Your Ref: OWPC18117
Our Ref: CM/7/18/PL 13-03-2018
Please ask for:
Mrs A Gardner

Change of use of land from agricultural field to 60 No. tent pitches operating from April to October to include 2 No. plumbed screened portable showers, 2 No. plumbed portable toilets, 2 No. screened changing cubicles, 2 No. 2 screened portable chemical toilets with hand wash facilities & washing up/drying area within existing building.

Woodpecker Camping Field Crookthorn Lane Climping

Thank you for your internet representation made on 7th May 2018 which has been recorded as '**an objection**' with the comments as follows:

site plan *1:200@A3*

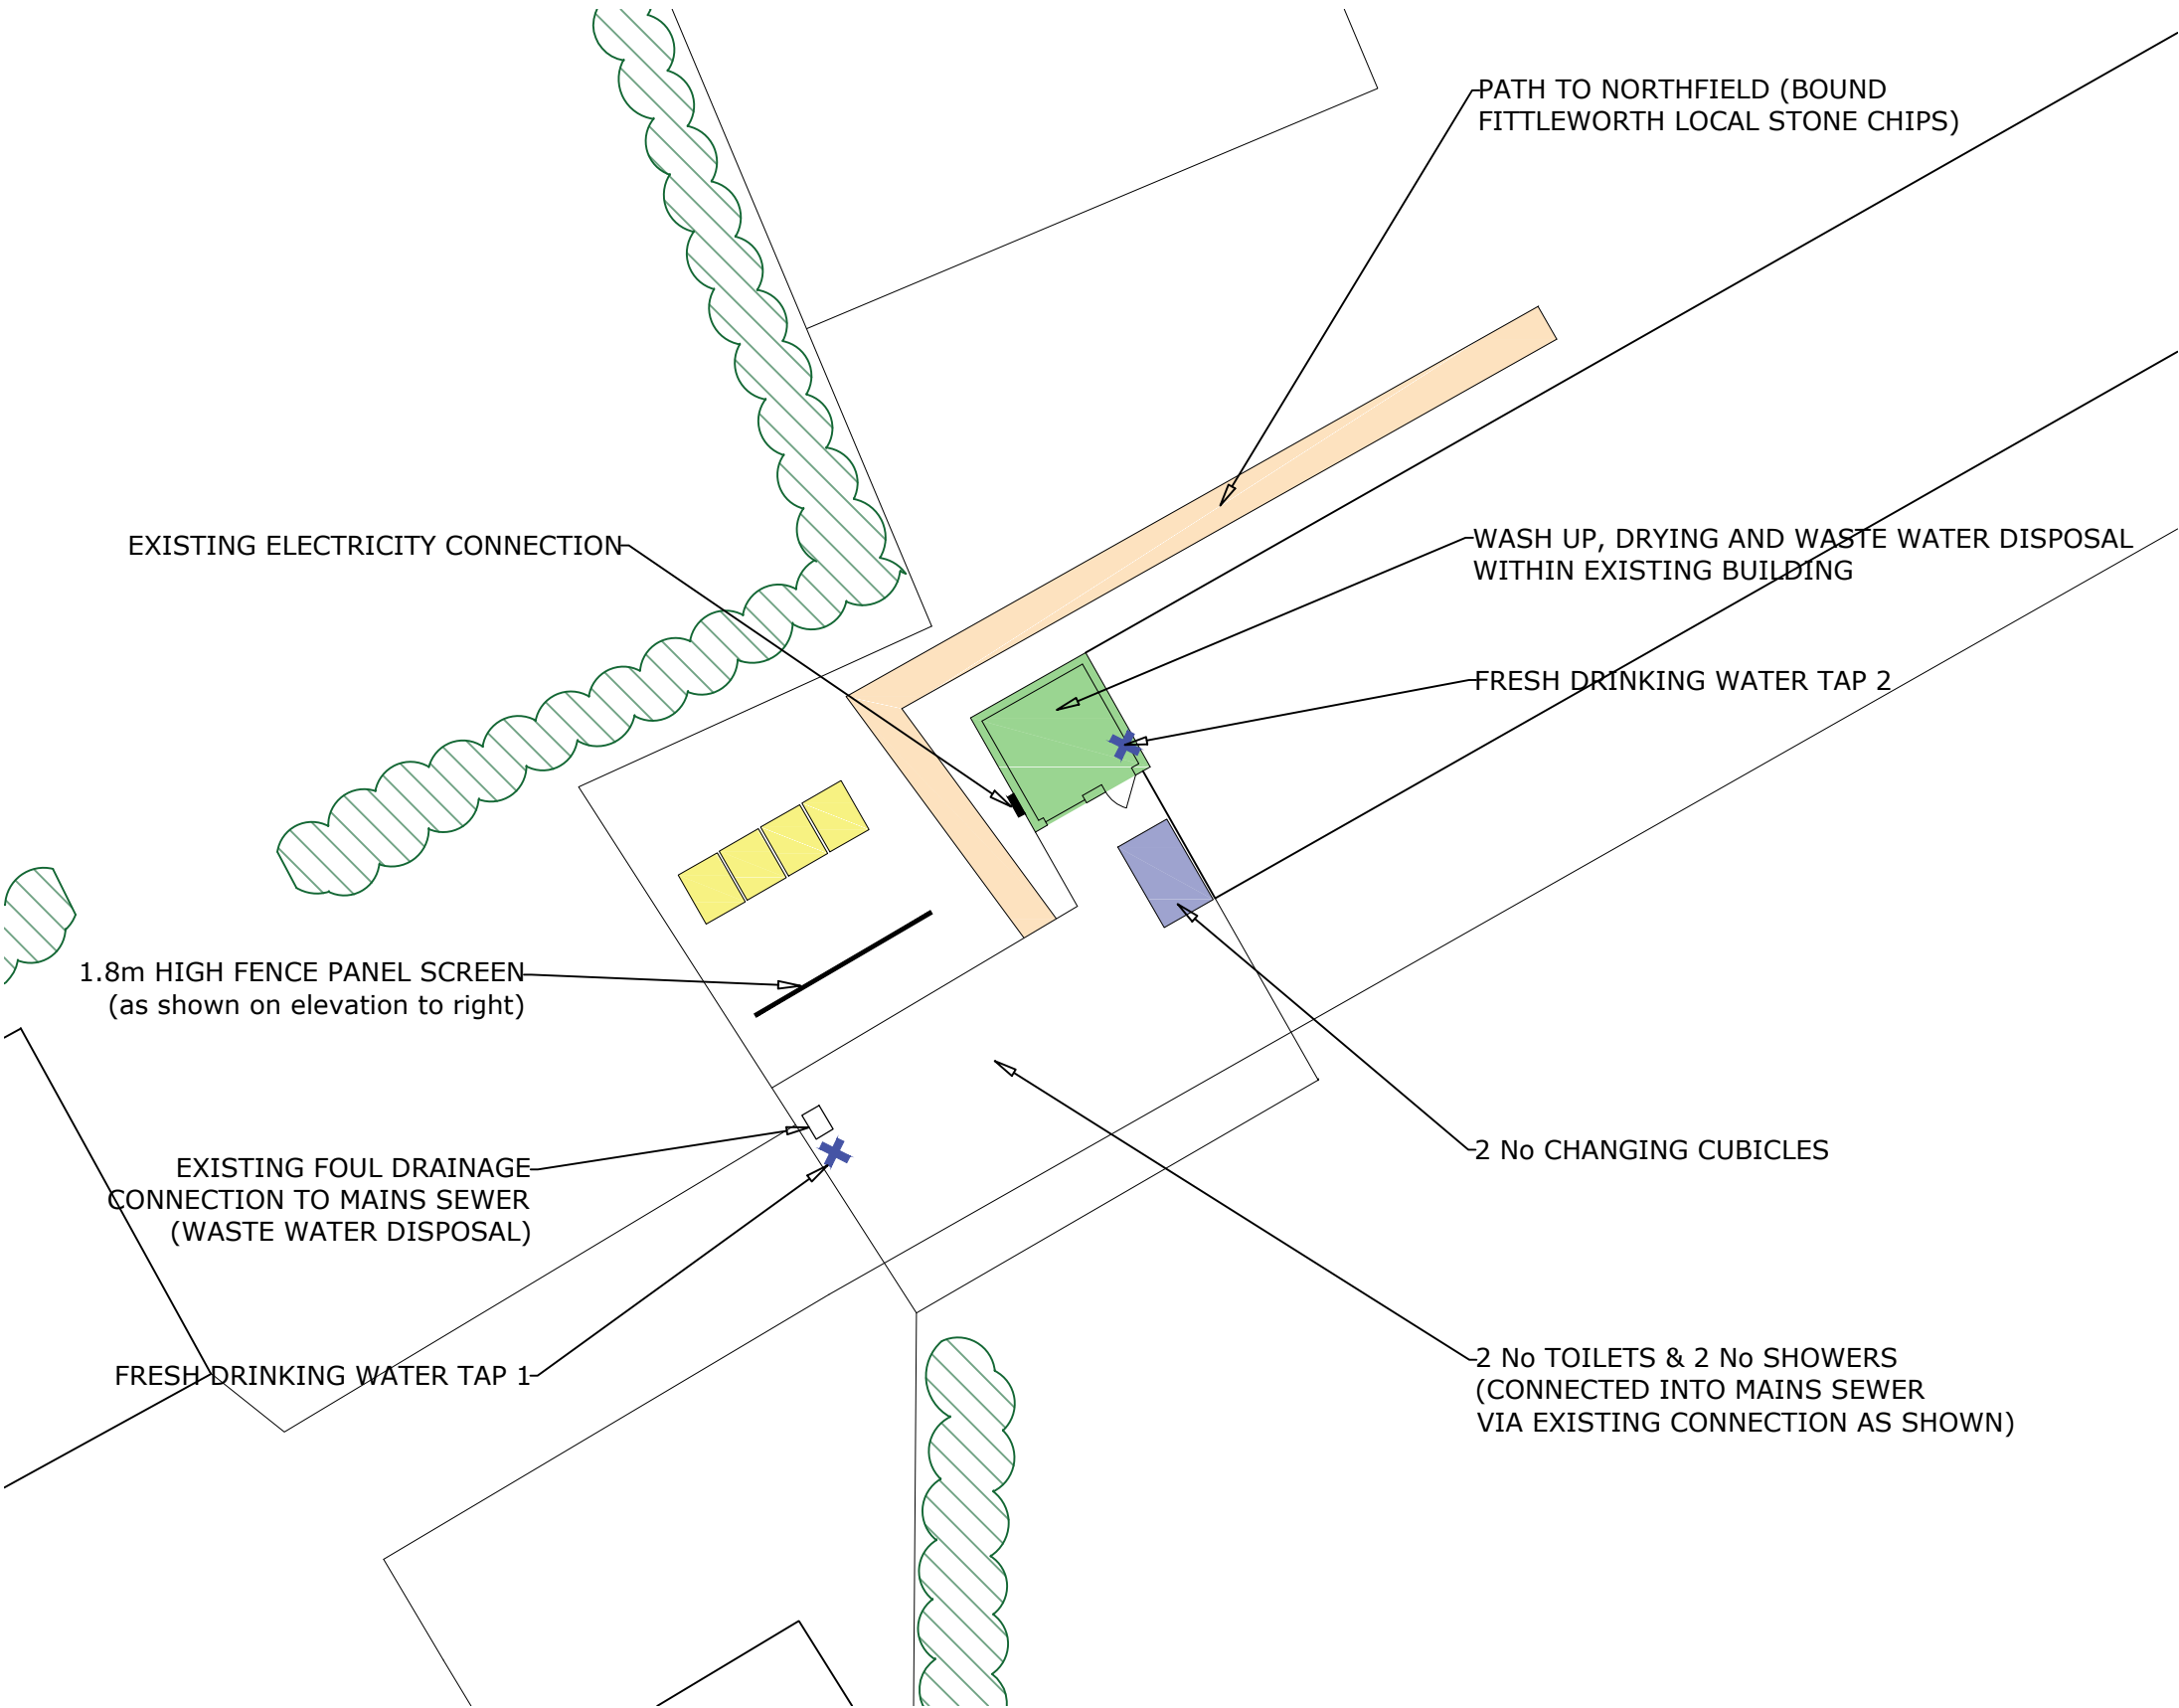
The main problem is the siting of the toilets and shower cubicles. There are only 2 residential properties that back on to the proposed site . and yet the chemical toilets and shower cubicles are planned to be sited right next to them. The reason given for this is to use existing sewers and water pipes, however I can see absolutely no reason why the toilets and showers cannot be sited at the rear of the existing farm shop which must currently have even better water and sewerage links. This would also make it far easier and safer to collect chemical waste as access would be via a tarmac road and not across a grass field which is occupied by tents and campers. The problem with the current plan is that chemical toilets smell and placing the toilets and showers and washup facilities all together will mean groups of people will collect at early and late times of the day right next to residential gardens..with inevitable unpleasant smells and noise being the result. We can block the view but groups of people chatting and using the far too small number of toilets will inevitably ruin the peace and quiet in the two gardens. Also the landowner has recently gained permission to convert the existing pig sty's on this site into holiday apartments. I cannot believe it is healthy to have outdoor chemical toilets and shower cubicles situated directly at the end of that development. They should not be there ... existing residents should be protected as there is a perfectly good alternative.
